**From:** [Borough Planning](#)  
**To:** [REDACTED]  
**Subject:** FW: 23/00007/F Sue Ryder 79 Westgate Hunstanton PE36 5EP  
**Date:** 22 February 2023 12:05:11  
**Attachments:** Shopfront detail Feb 23.pdf  
image002.png  
image003.png  
image004.png  
image005.png

**Subject:** 23/00007/F Sue Ryder 79 Westgate Hunstanton PE36 5EP

Title:  
 SHOPFRONT DETAILS

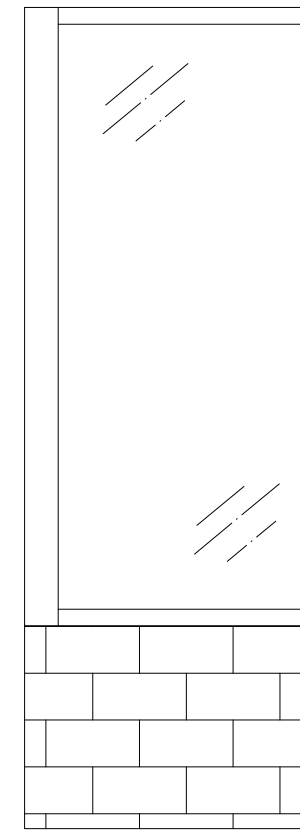
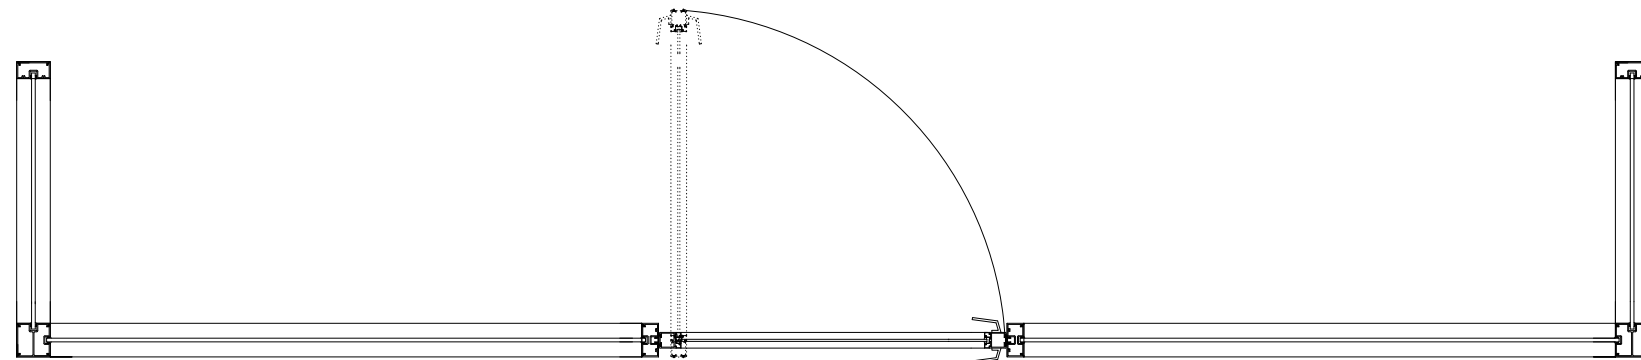
I am sorry, but this plan is still not to scale. It may be the way its been saved or scanned.

I apologise for this. The application is invalid as the proposed plan is not to scale and I need confirmation that both side elevations are the same.
